Your Ref: OWPC19489
Our Ref: A/36/18/OUT 12-03-2018
Please ask for:
Mrs A Gardner

Outline planning application with some matters reserved for the erection of up to 200 dwellings with access, public open space, landscaping and sustainable drainage system (SuDS) with vehicular access point from Arundel Road, one full-sized adult football pitch and the demolition of industrial units and one residential dwelling. Departure from the Development Plan.

Land off Arundel Road Angmering

Thank you for your internet representation made on 6th August 2018 which has been recorded as **'no objection'** with the comments as follows:

Figure 5.1: Development Framework Plan.

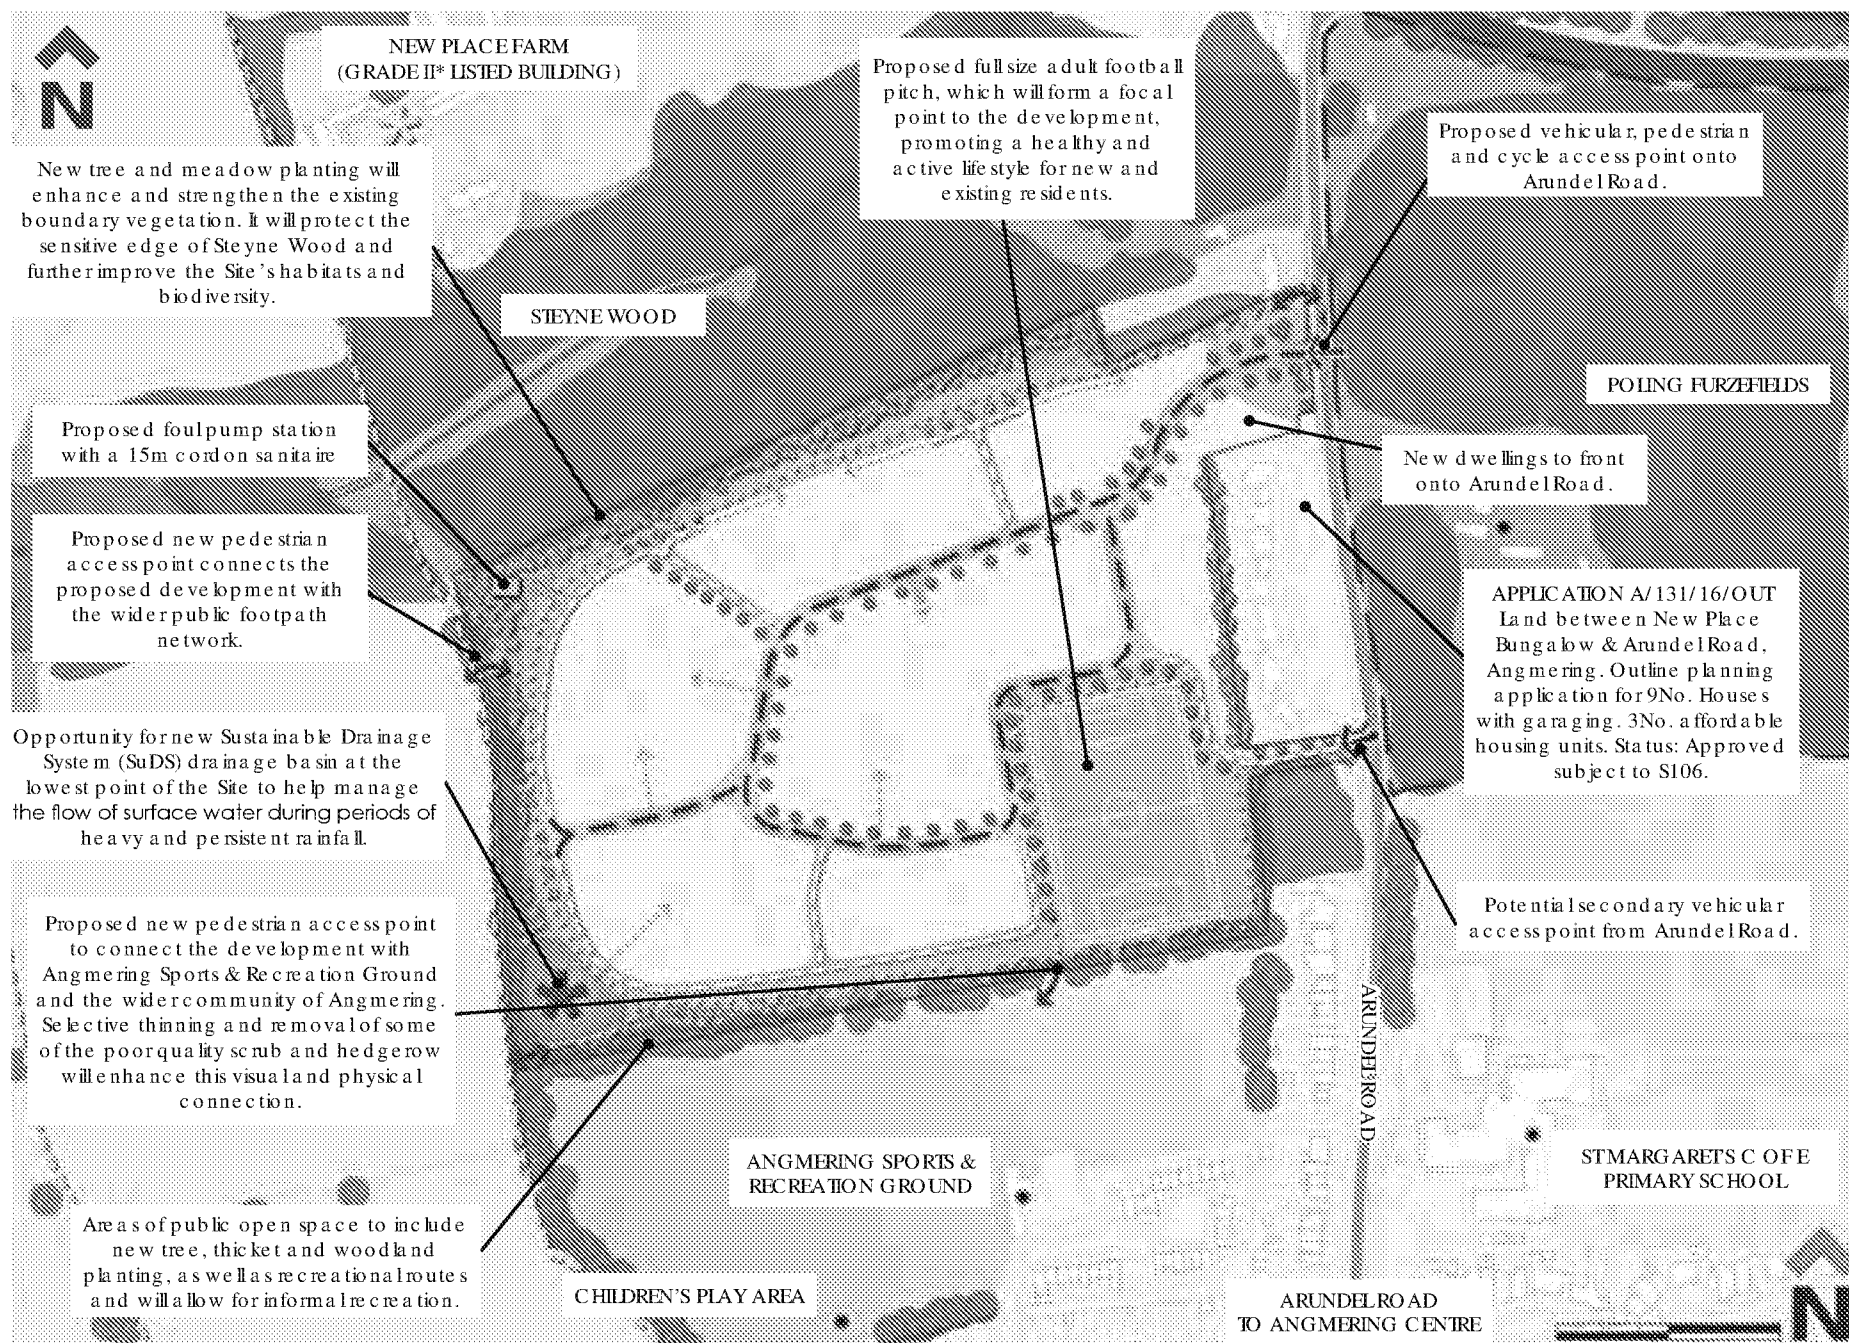
However, and unfortunately, the amended reports / strategies and slightly alter development framework plan does not go far enough to address our previous concerns, and in one particular aspect (the lack of connectivity to the wider PROW and 'potential' access to the Angmering Sports and Recreation Ground) it is a step backwards.

Therefore, our previous comments (dated 18th May 2018) still stand.
